**Submission on ENVIRONMENTAL ASSESSMENT INVINCIBLE COLLIERY PA
07_0127 MODIFICATION AND CULLEN VALLEY MINE DA 200-5-2003
MODIFICATION**

By the Colo Committee

Figure 4: Biodiversity Offset Areas

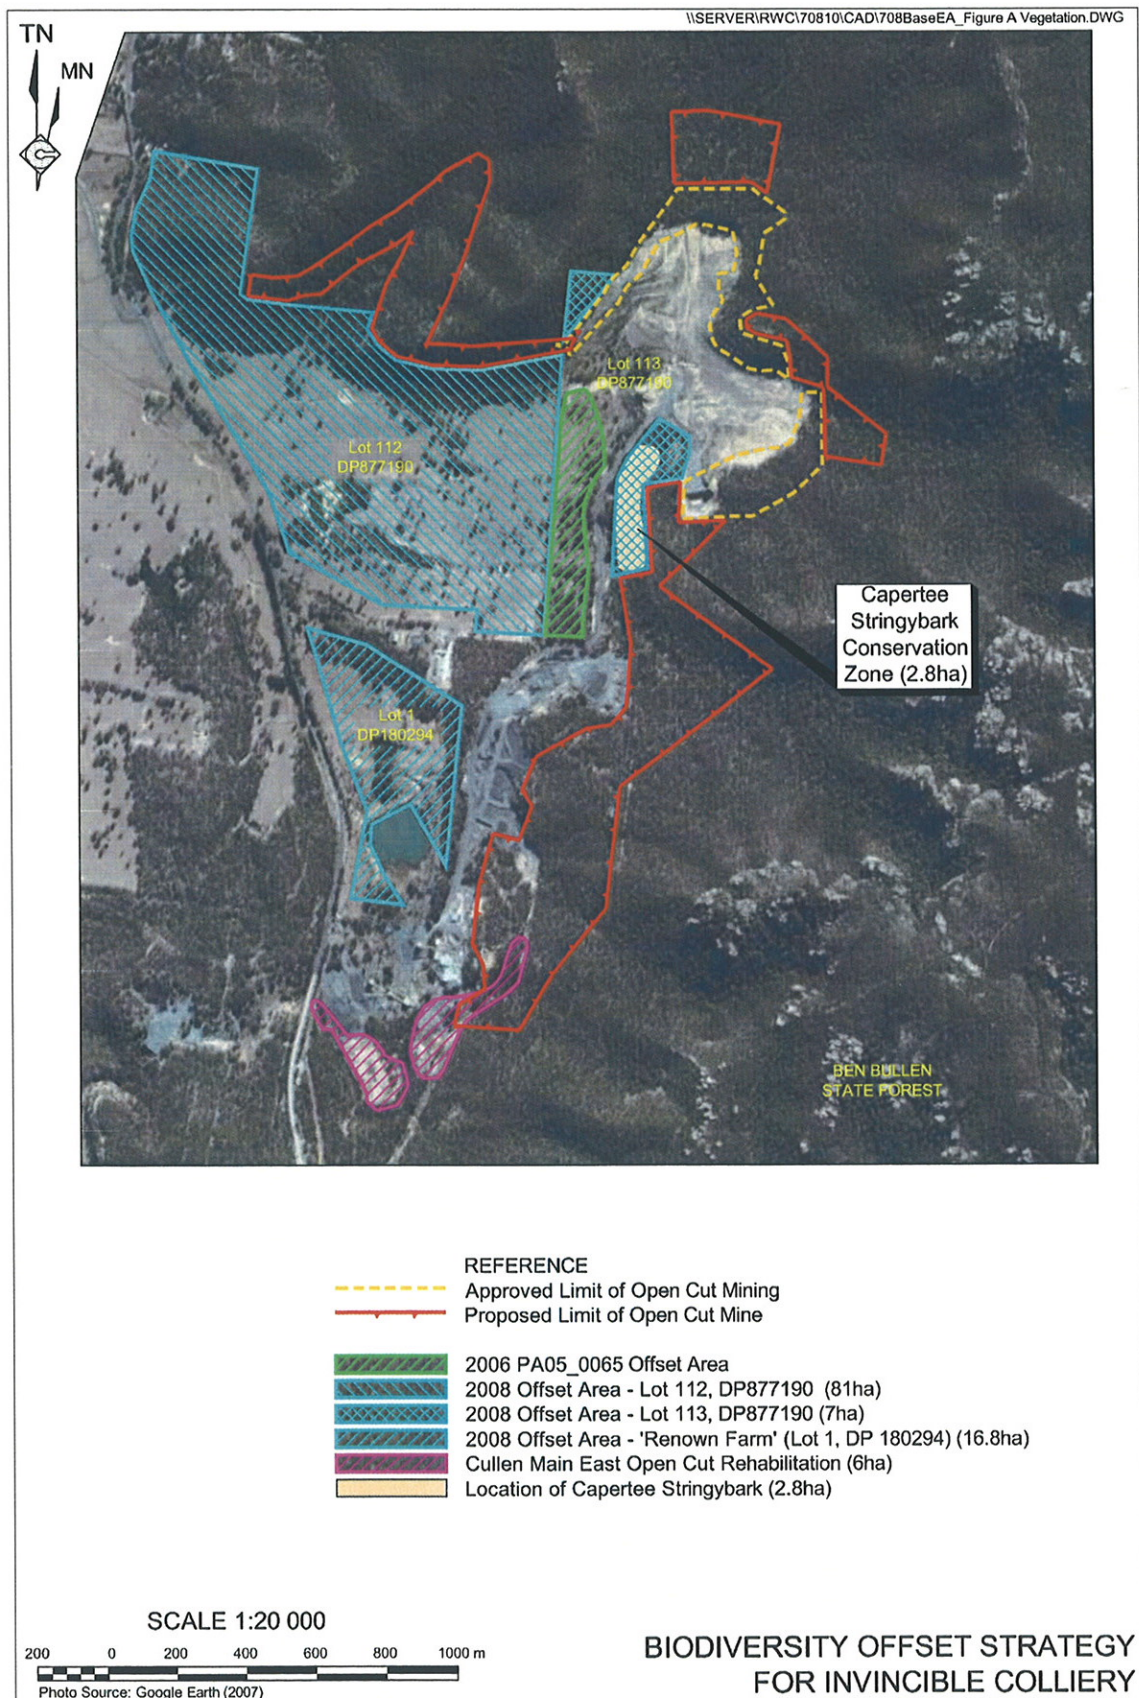
There are very real grounds to believe that the proposed offsets do not meet the criteria of 'like for like'. This was detailed in previous submissions on the Coalpac Consolidation Project. Figure 3 of the EA shows that a large part of the proposed offset is in fact cleared land to the west of the current Invincible open cut. This is not acceptable as a 'like for like' offset.
